Our ref: DOC20/734438
Senders ref: SSD 8194

Subject: Dendrobium Mine Extension Project – Amendment Report – SSD 8194

We have reviewed the applicant's amendments and provided advice on the outstanding matters raised in our Response To Submissions (RTS) letter dated 9 March 2020. Please also note that, as of 1 July 2020, Department of Premier & Cabinet (Aboriginal Cultural Heritage Regulation) are now responsible for dealing with Aboriginal cultural heritage matters and will respond separately regarding the heritage matters raised in BCD's previous advice on the RTS.

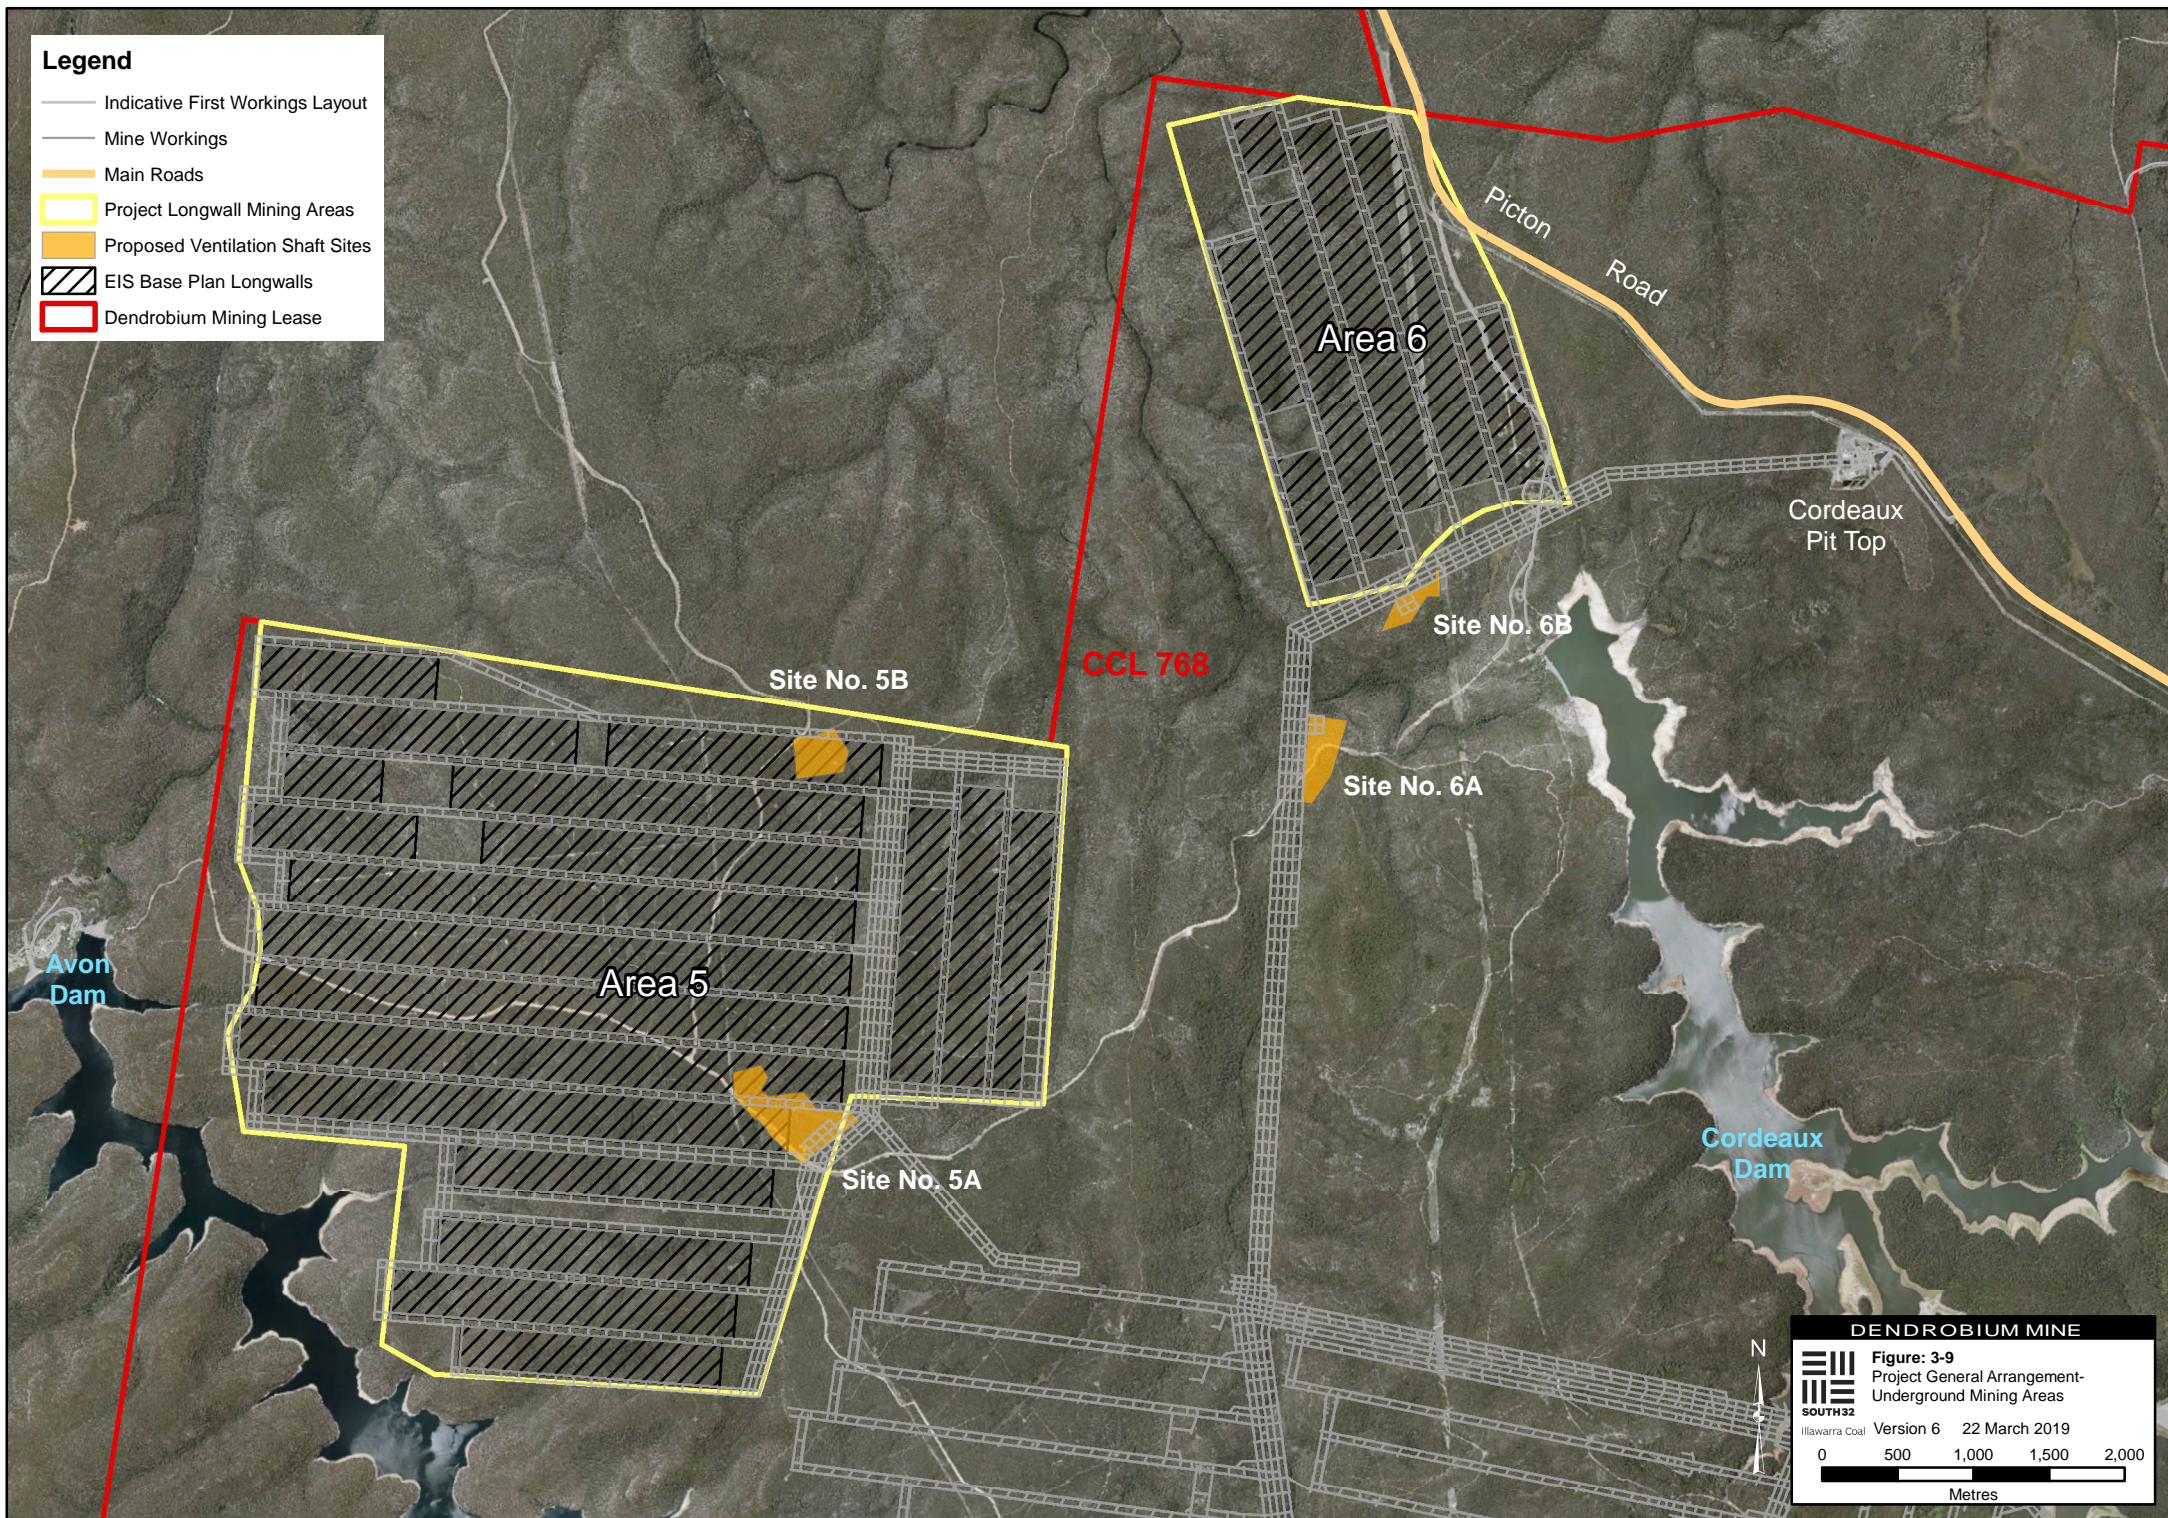
- There are only minor changes to the proposed longwall mining layout which was presented in the RTS, comprising a 306m reduction of LW 516 in the vicinity of Avon Dam, and the proposed 305m wide longwalls are retained. While this reduction is noted, the amended layout does not materially reduce the impact upon Coastal Upland Swamps in particular. In its current form the proposed mine layout remains likely to have a significant impact on threatened species and ecological communities and in our opinion, does not satisfactorily demonstrate the "avoid" principle has been met.
